Byers Gill Solar EN010139

3.3 DCO Schedule of Changes

Revision 8

January 2025

Drawing Title
Street Works, Public Rights of Way & Access Plans
Sheet 3 of 13
APFP Regulation 5(2)(k)

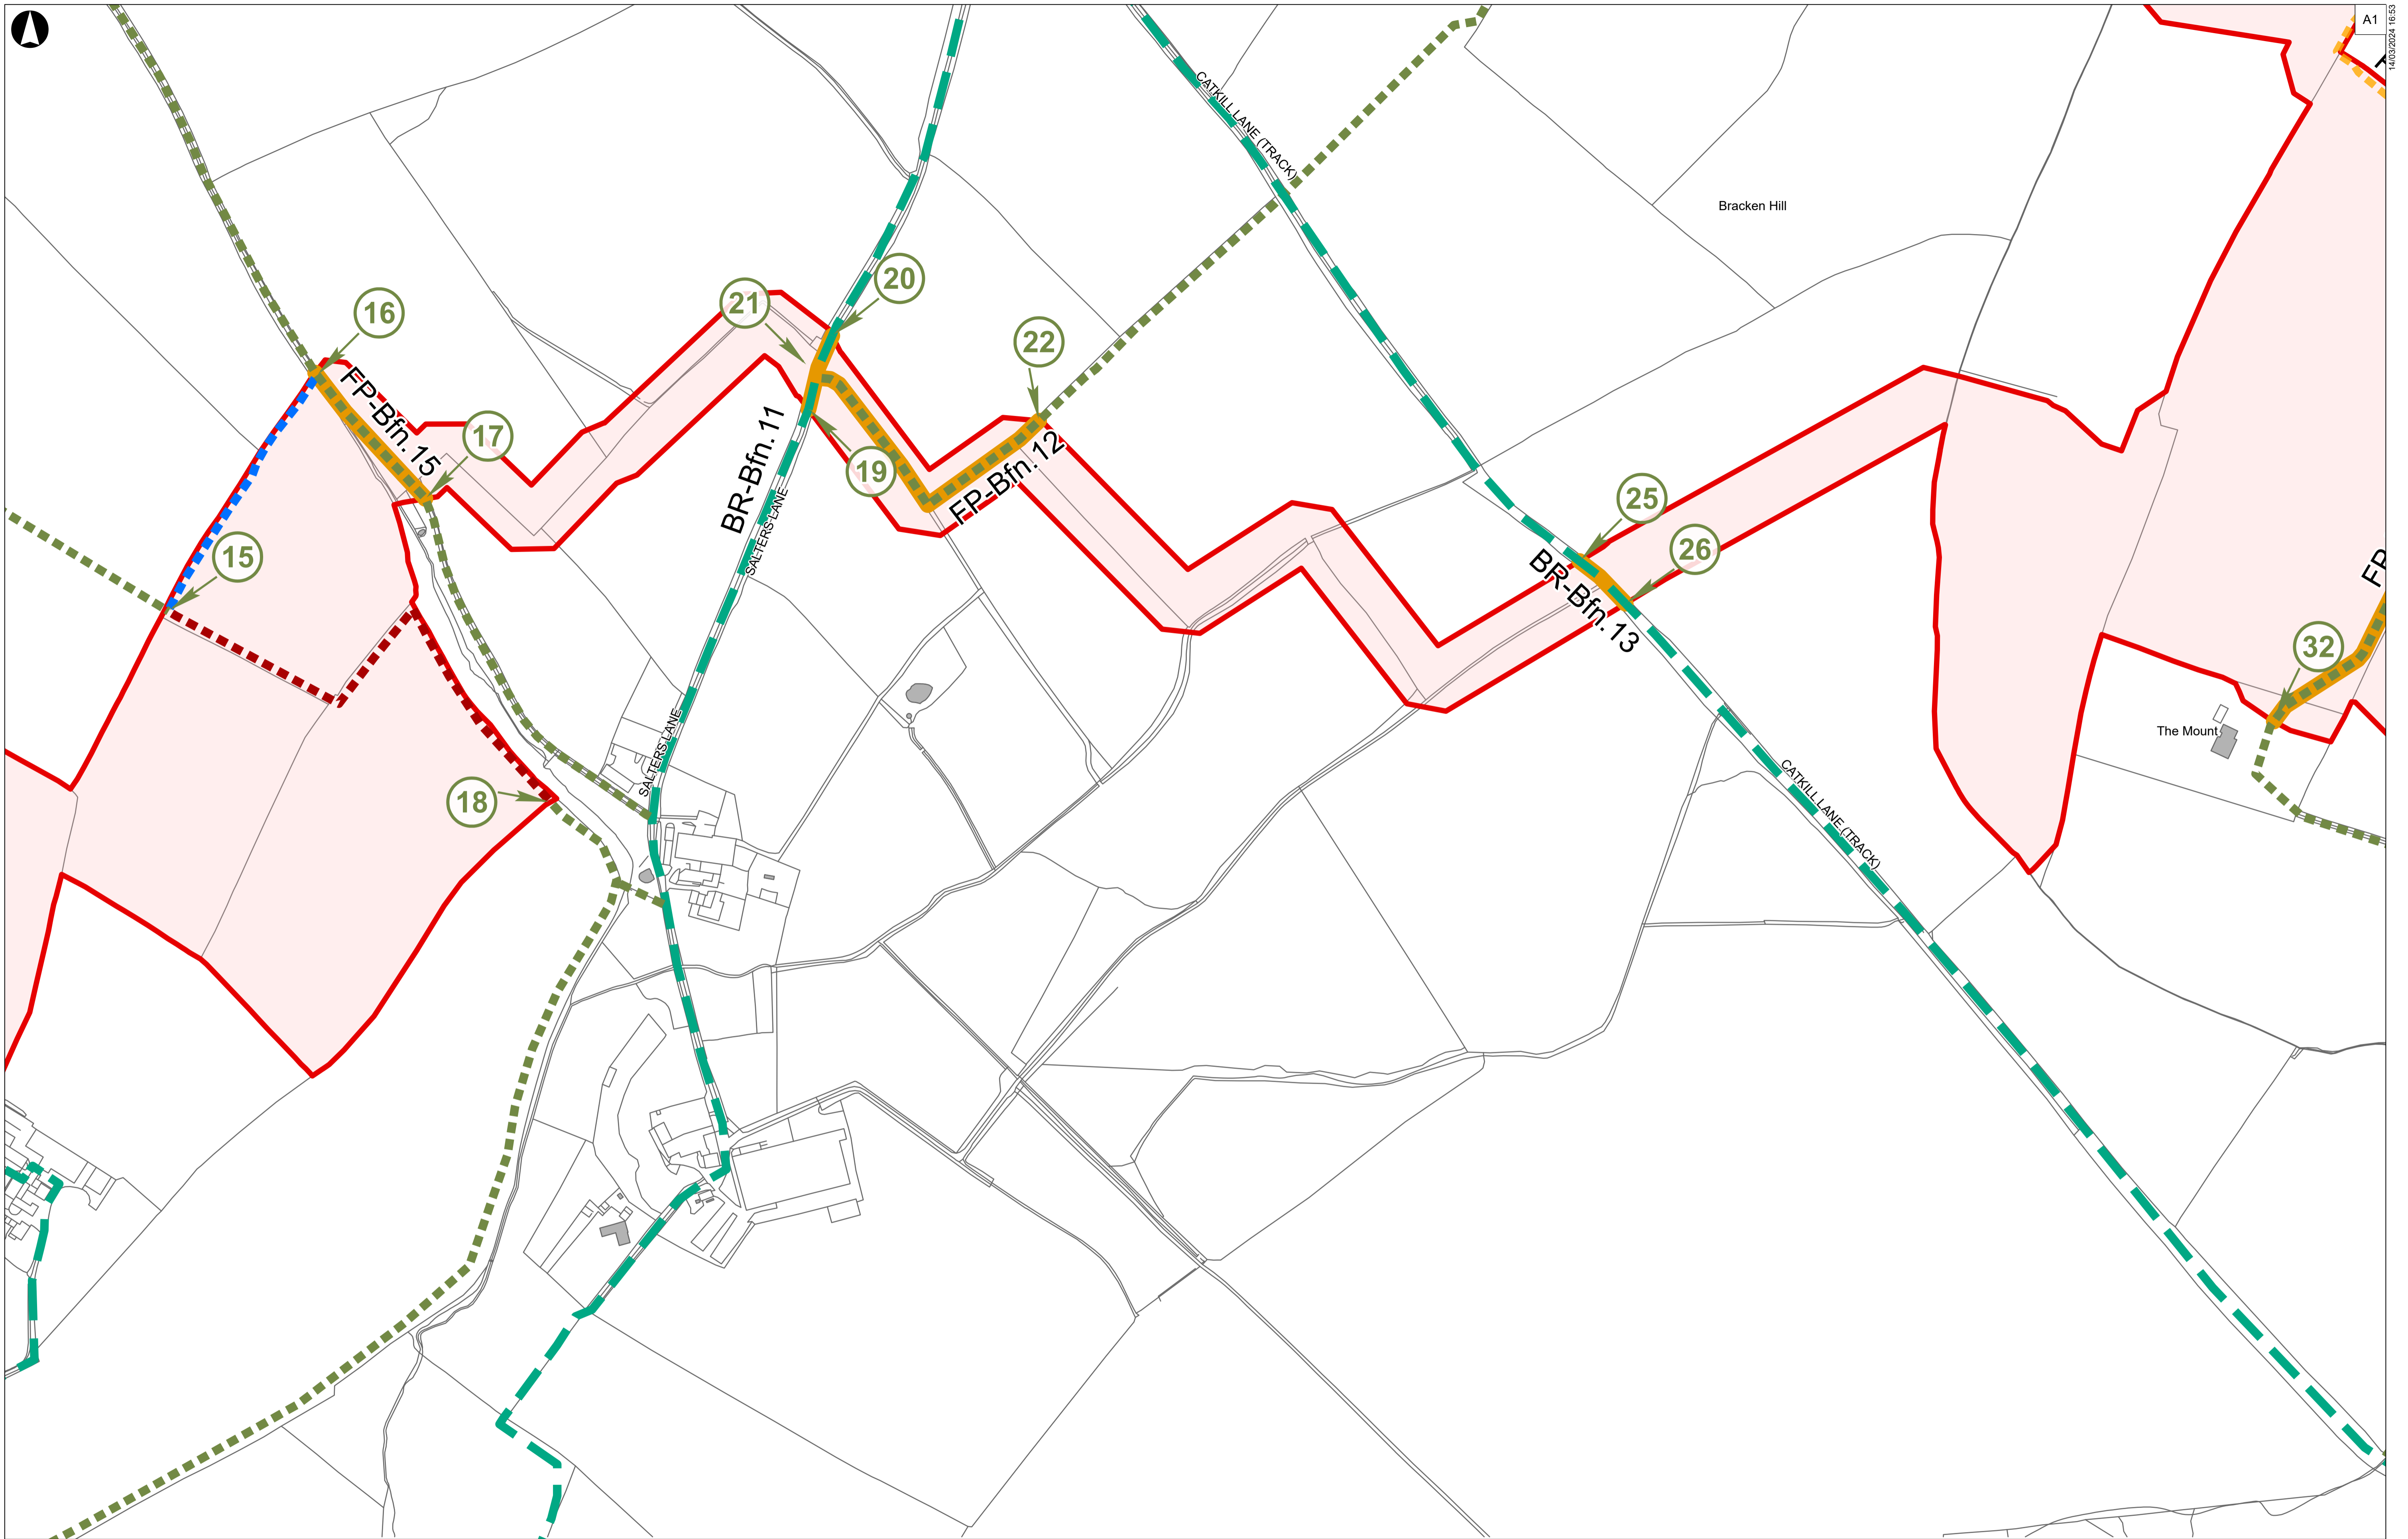
| <i>Parish of Brafferton</i> | <i>Unnamed Road</i> | <i>Cable works beneath the width of highway <u>street</u> comprising a length of 320m as shown between points marked A and B on sheet 3 of the street works, public rights of way and access plans.</i> |

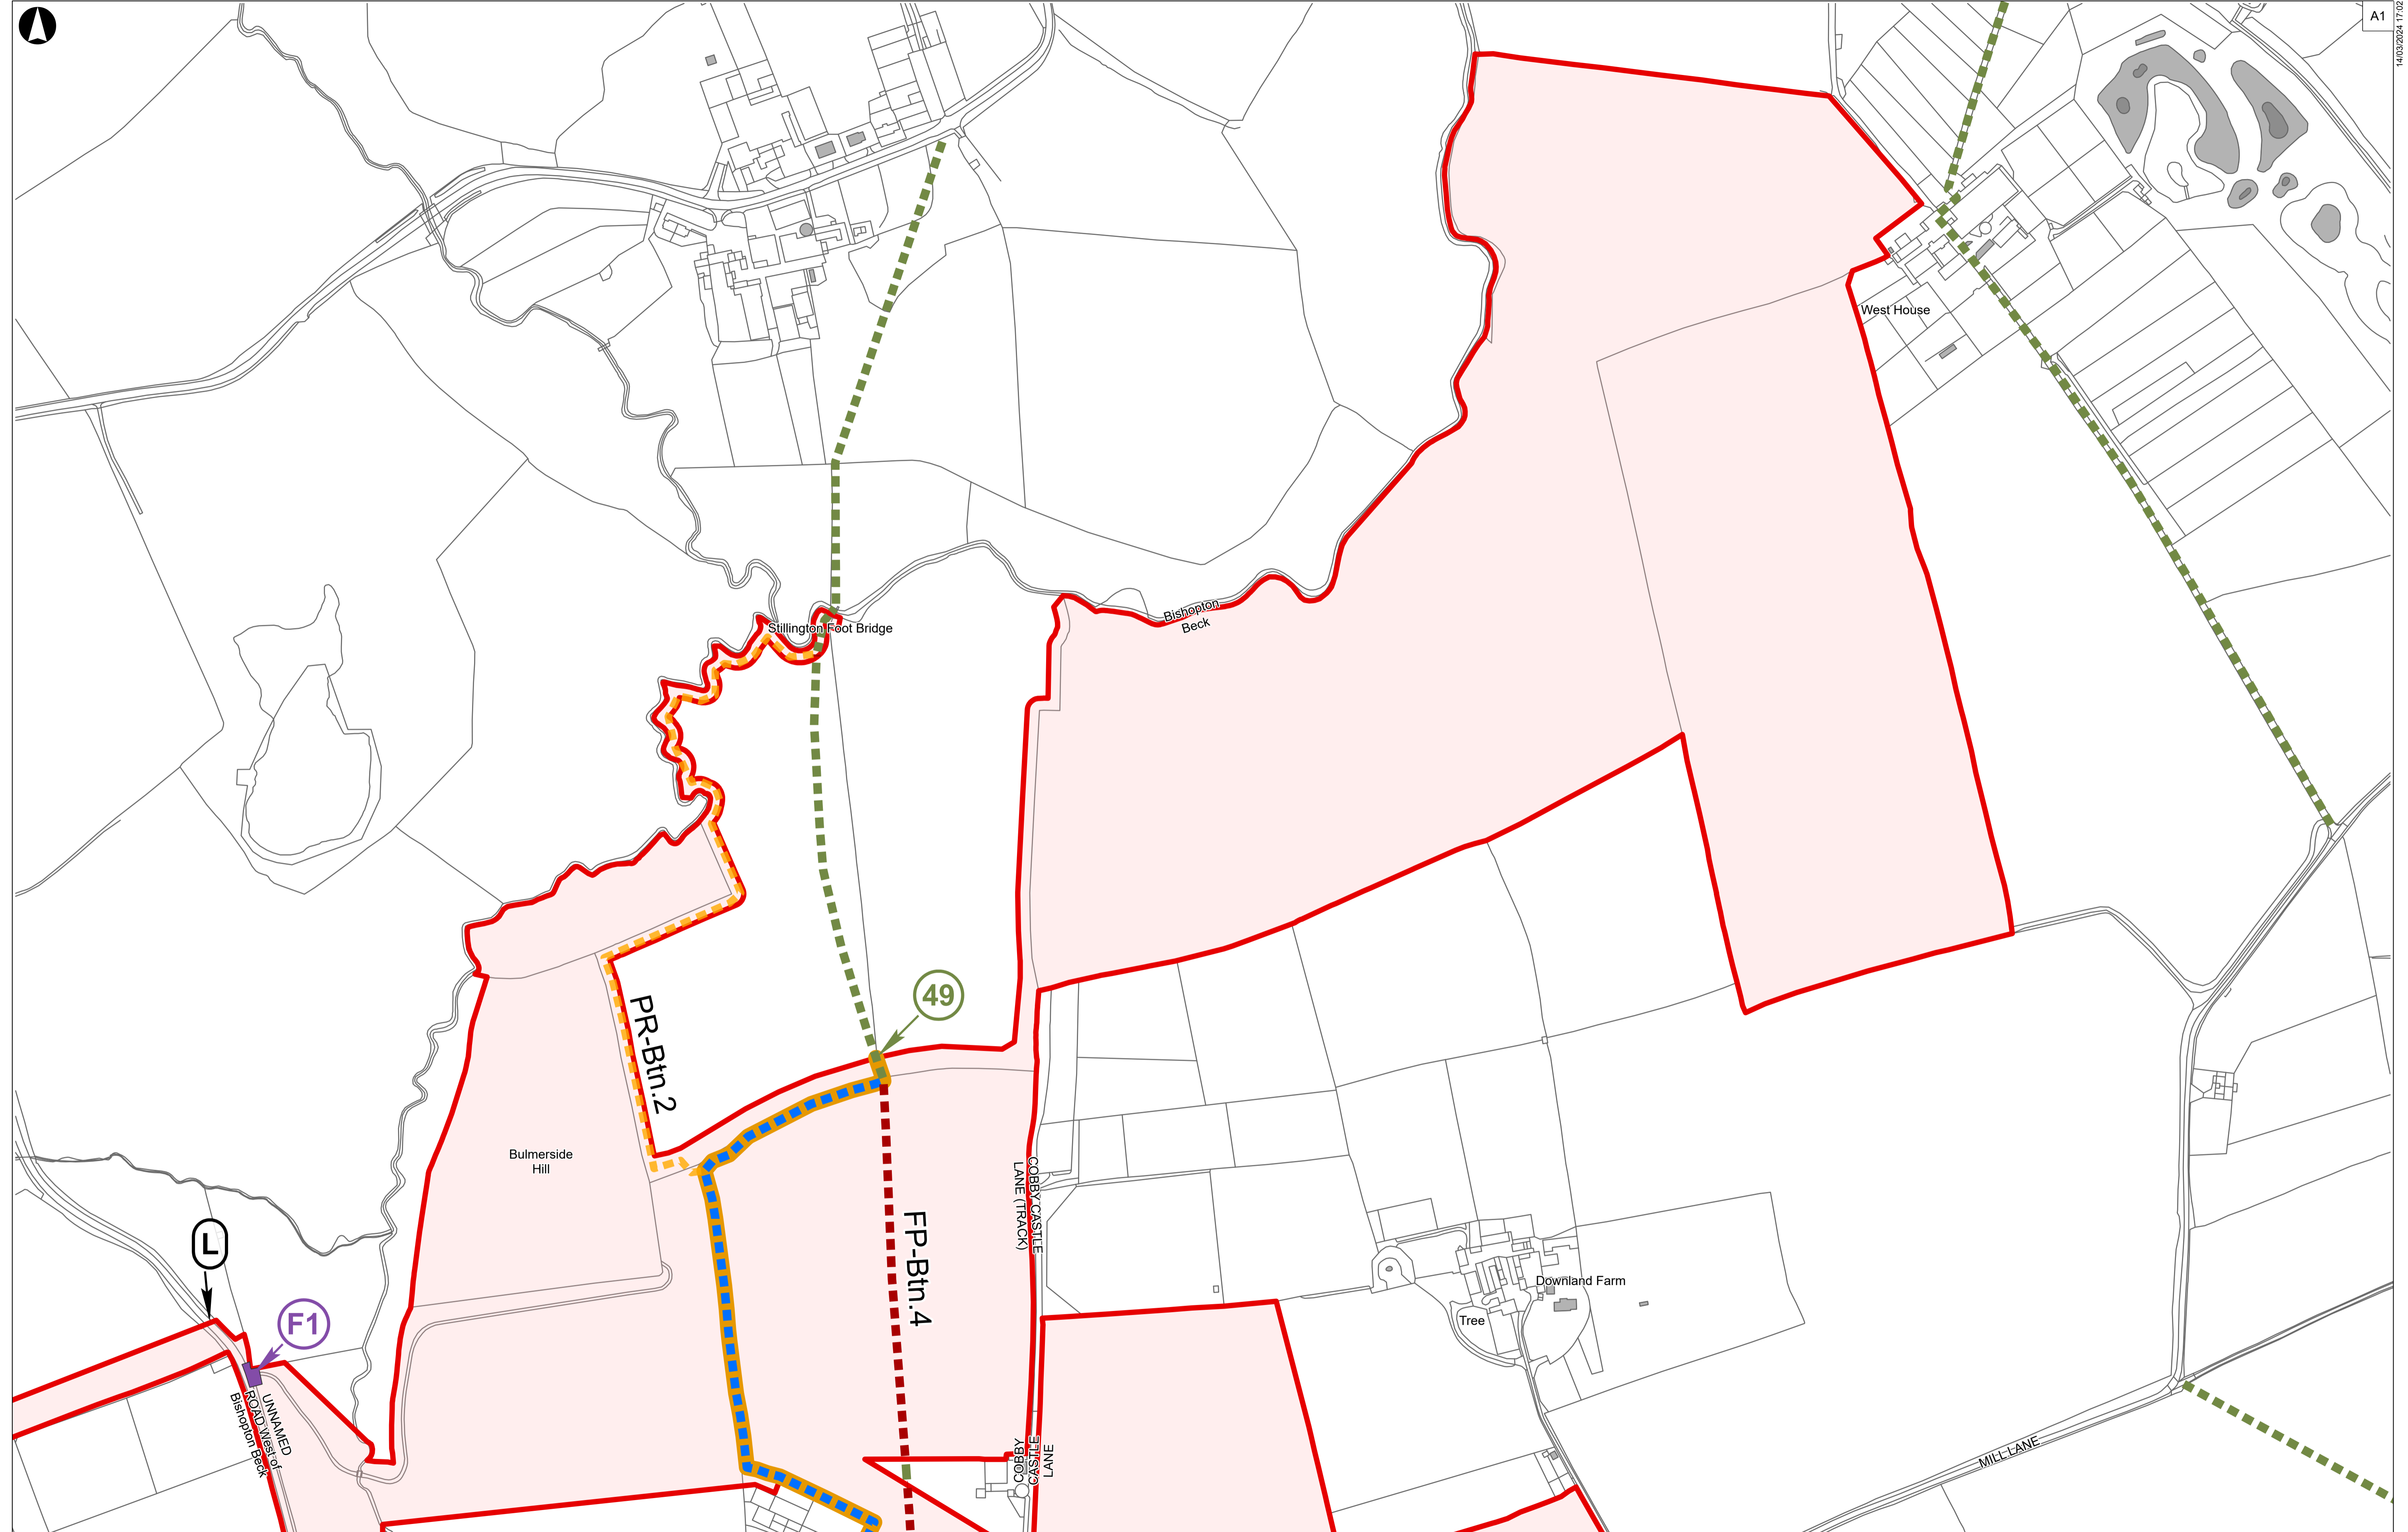
| <u>Parish of Bishopton</u> | <u>Folly Bank</u> | <u>Cable works beneath the width of street as shown with reference CC5 on sheet 9 of the street works, public rights of way and access plans.</u> |

These two rows have been added to provide street works descriptions for two locations where the Applicant proposes to carry out cabling works across the width of a street for the purpose of delivering the off-road cable route. These descriptions are included as a correction to Revision 1 of the dDCO.

Corresponding amendments have been made to the Street Works, Public Rights of Way and Access Plans to indicate these locations.
